**Tallowong Station Precinct South Stage 2 (SSD-10425) and (SSD-9063-MOD-1)  
Request for Additional Information**

I refer to the Response to Submissions for the Tallowong Station Precinct South Stage 2 SSD and Modification Application. After careful consideration, the Department requests that you provide the following additional information:

# PRIVATE ROAD DESIGN

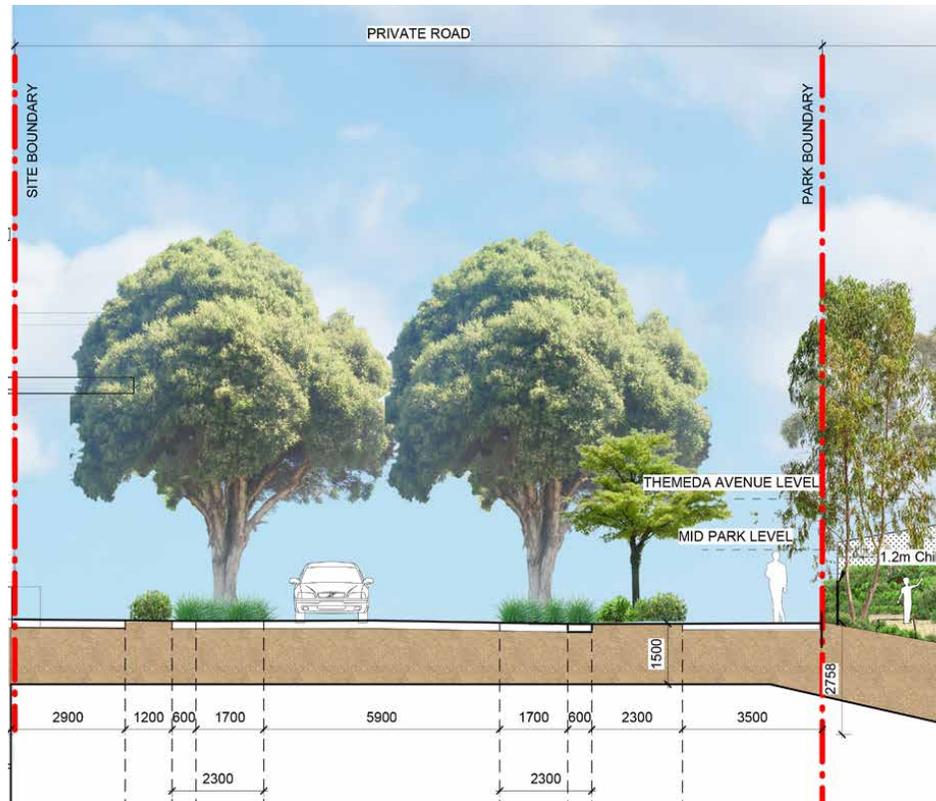
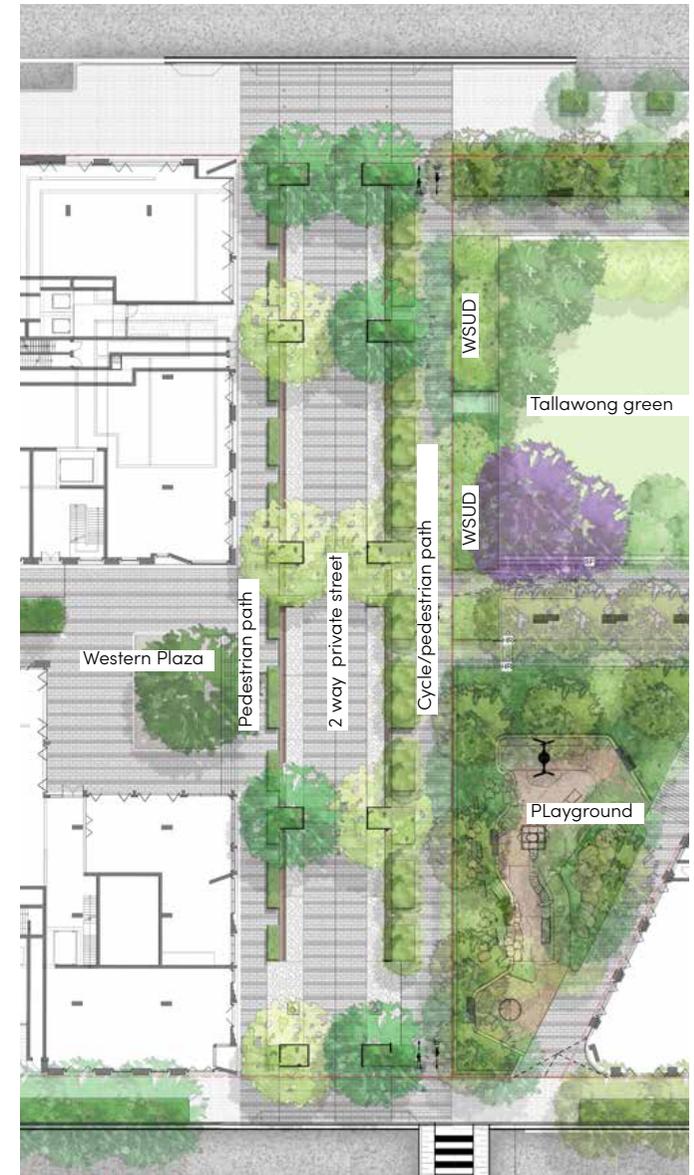
- amend the Addendum Urban Design Report - 4.2 Private Road Design to correctly identify "private shared street"
